11/08/2020

**St Francis College Stage 1 - Landscaping (SSD-10365)  
Response to Submissions**

- EXISTING TREES TO BE REMOVED
- EXISTING TREES TO BE RETAINED
- PROPOSED FEATURE TREE PLANTING
- PROPOSED SHRUB AND ACCENT PLANTING
- PROPOSED GROUNDCOVER PLANTING
- PROPOSED MATRIX PLANTING
- STAGE ONE SCOPE OF WORKS
Everything outside this scope are part of a separate approval

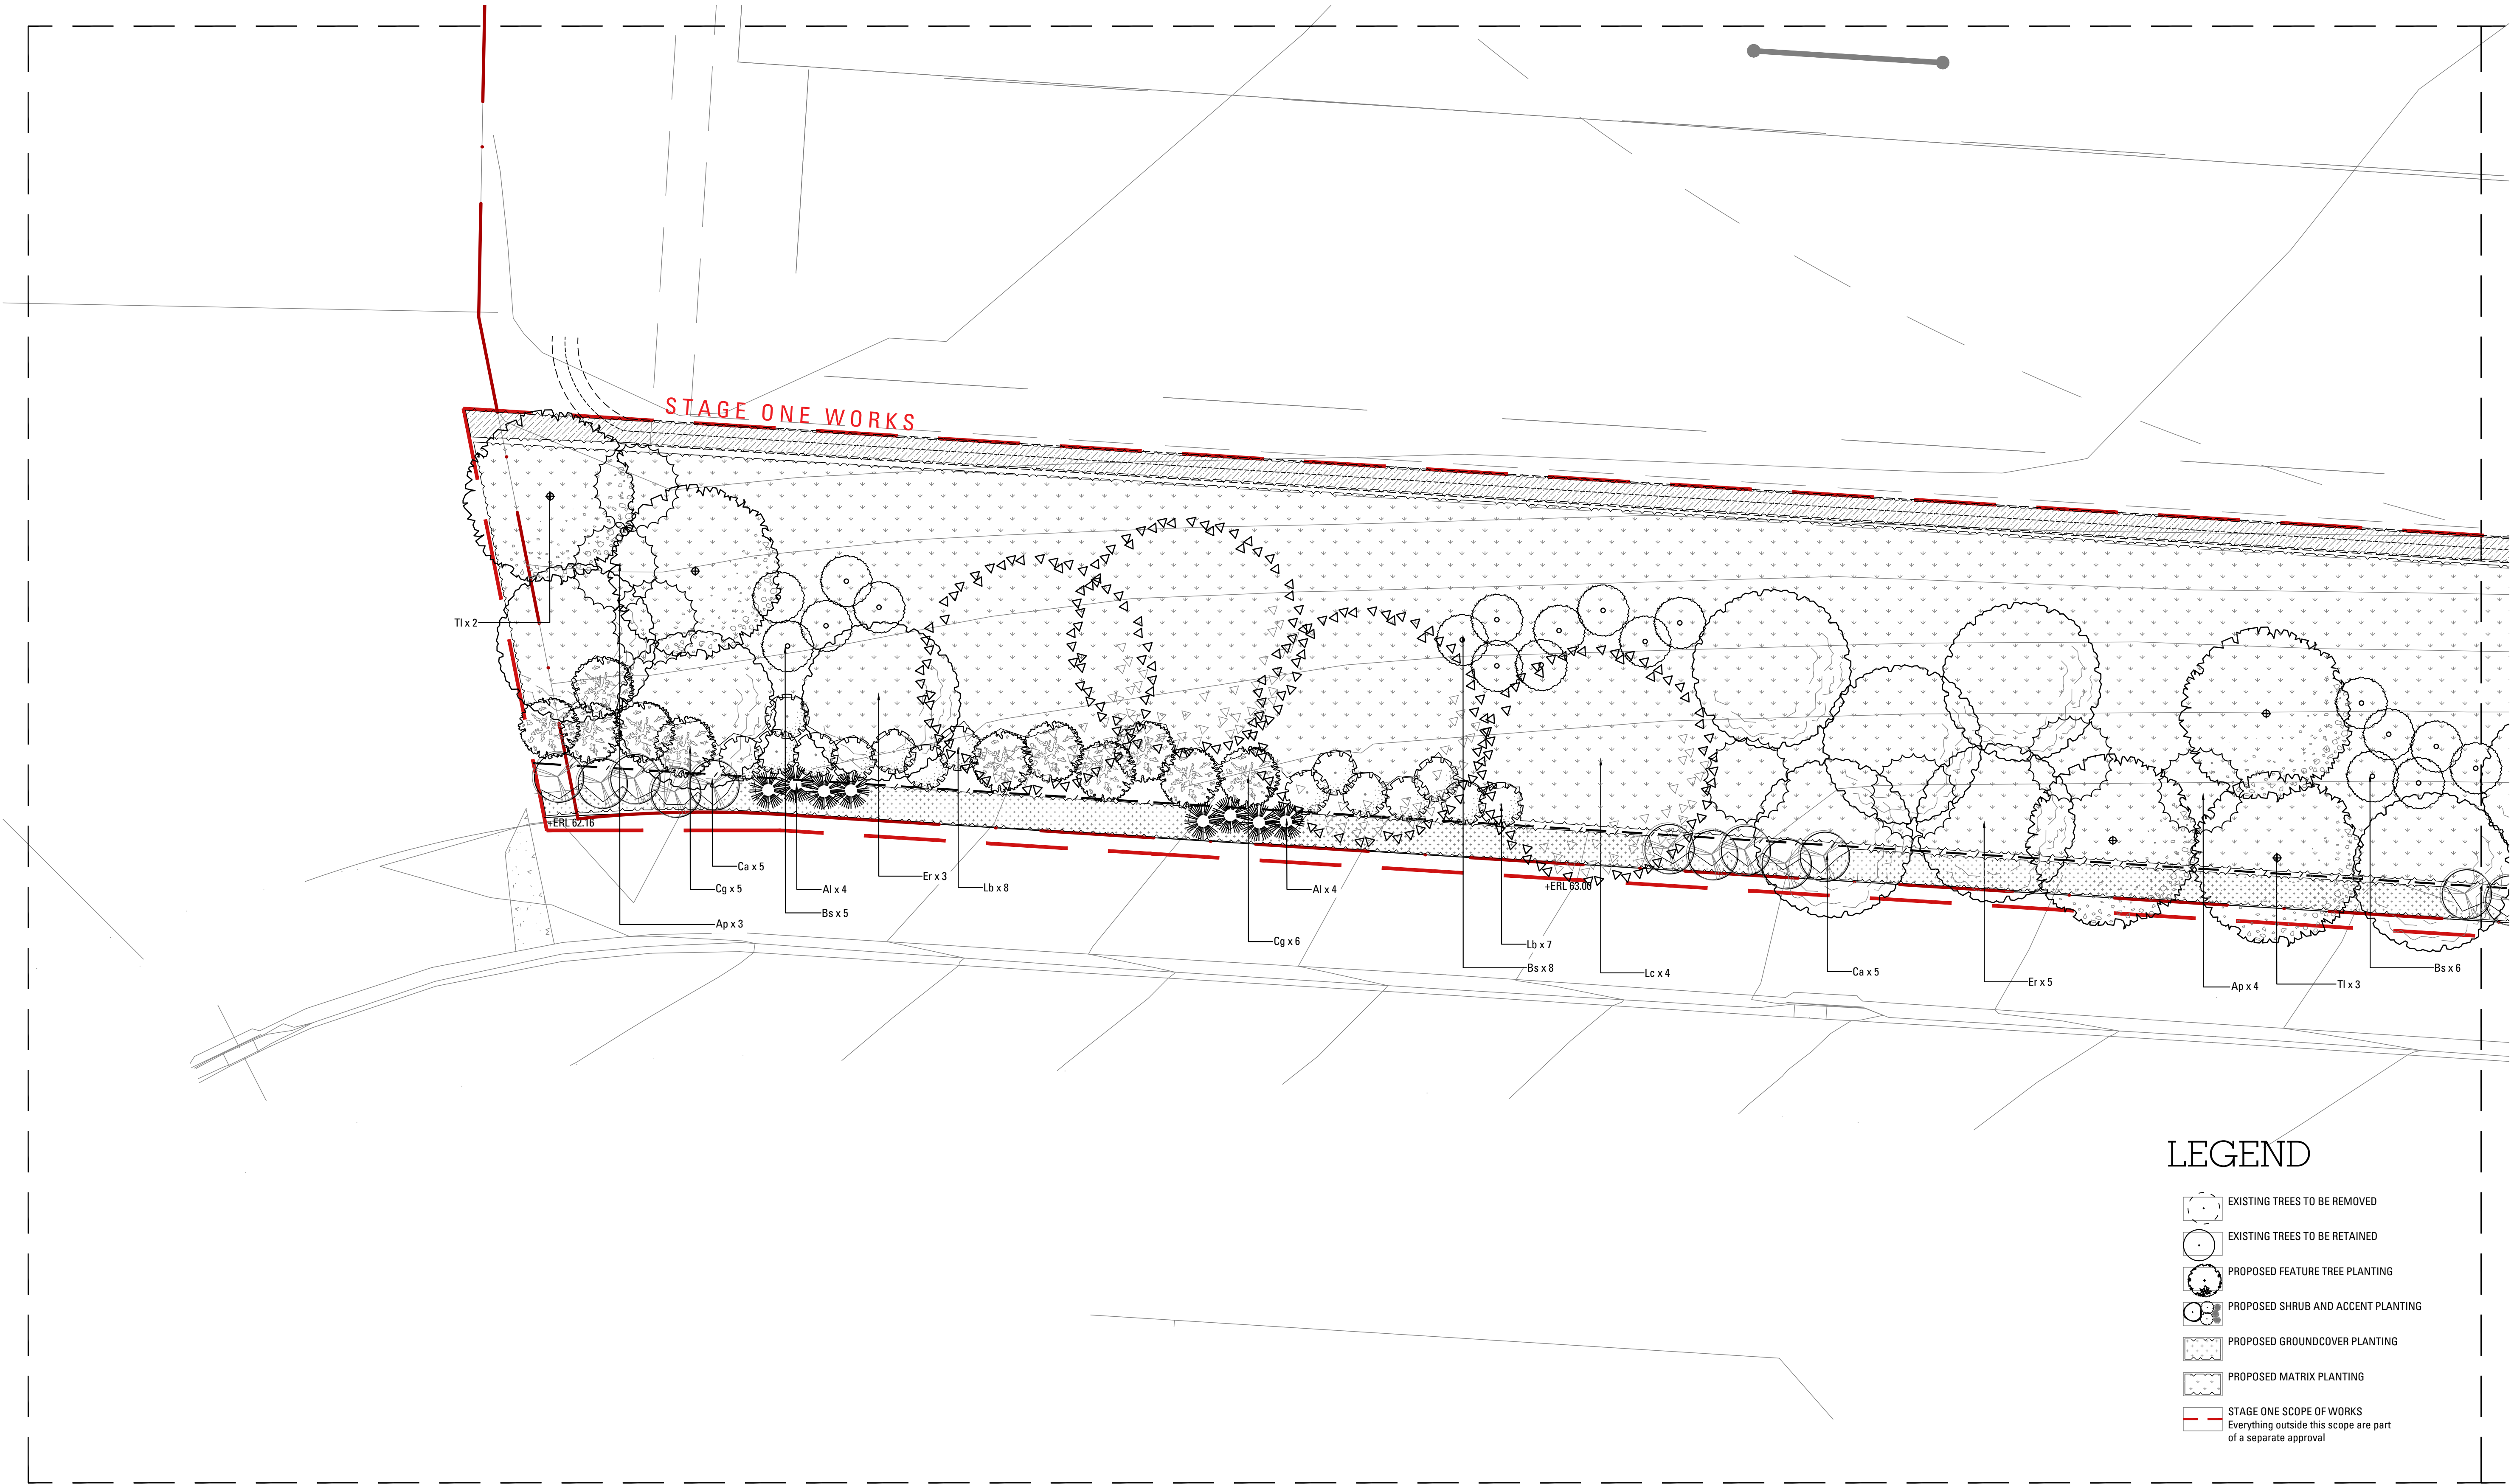
- The submitted Proposed Site Plan (reference: 1130 SSD11 Rev 01; dated: 11/02/2020) does not clearly identify the development footprint for which approval is sought under this development application. Plans intended for approval need to clearly identify the proposed development footprint for Stage 1. Any works falling outside of the development footprint would require a separate consent and would be treated as indicative only. It is suggested that an appropriate key be used to distinguish and identify Stage 1 works from other works shown on the plan for context
